OXFORDSHIRE COUNTY COUNCIL'S RESPONSE TO CONSULTATION ON THE FOLLOWING DEVELOPMENT PROPOSAL

Application no: 22/00489/F

Proposal: Erection of 49 dwellings (17 of which (35%) will be affordable homes) with associated garages, parking and refuse storage, private gardens and communal open space/play space, hard and soft landscaping (including SUDs feature and means of enclosure, reinstatement of hedging and ironstone walling along Rattlecombe Road)

Location: Adjoining Stocking Lane And North Of Rattlecombe Road Stocking Lane Shenington

TITLE:
PLANNING LAYOUT

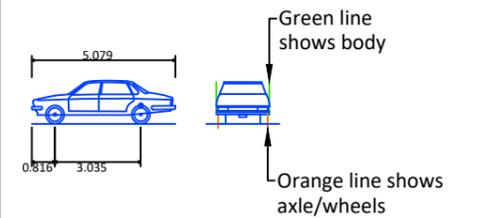
OCC require a swept path analysis for an 11.6m in length refuse vehicle passing an on-coming or parked family car throughout the layout. The carriageway will require widening on the bends to enable this manoeuvre.

The carriageways that are straight for over 70m will require some form of traffic calming to ensure vehicle speeds are less than 20mph. Cycling facilities must accord with LTN1/20.

Where there is not a footway adjacent to the carriageway a 6-metre-wide shared surface block paved carriageway with a minimum 800mm grass margin on either side is required.

A long section has not been provided and will be required to ensure compliance with the Equalities Act 2010. This must include details of the vertical alignment to determine appropriate carriageway and footway gradients. They will need to be DDA compliant i.e. maximum 1:21 or 5%.

There are no visibility splays indicated. Junction and Forward Visibility Splays and dimensions must be in accordance with the OCC Street Design Guide and dedicated to OCC if they fall out of the existing highway boundary.
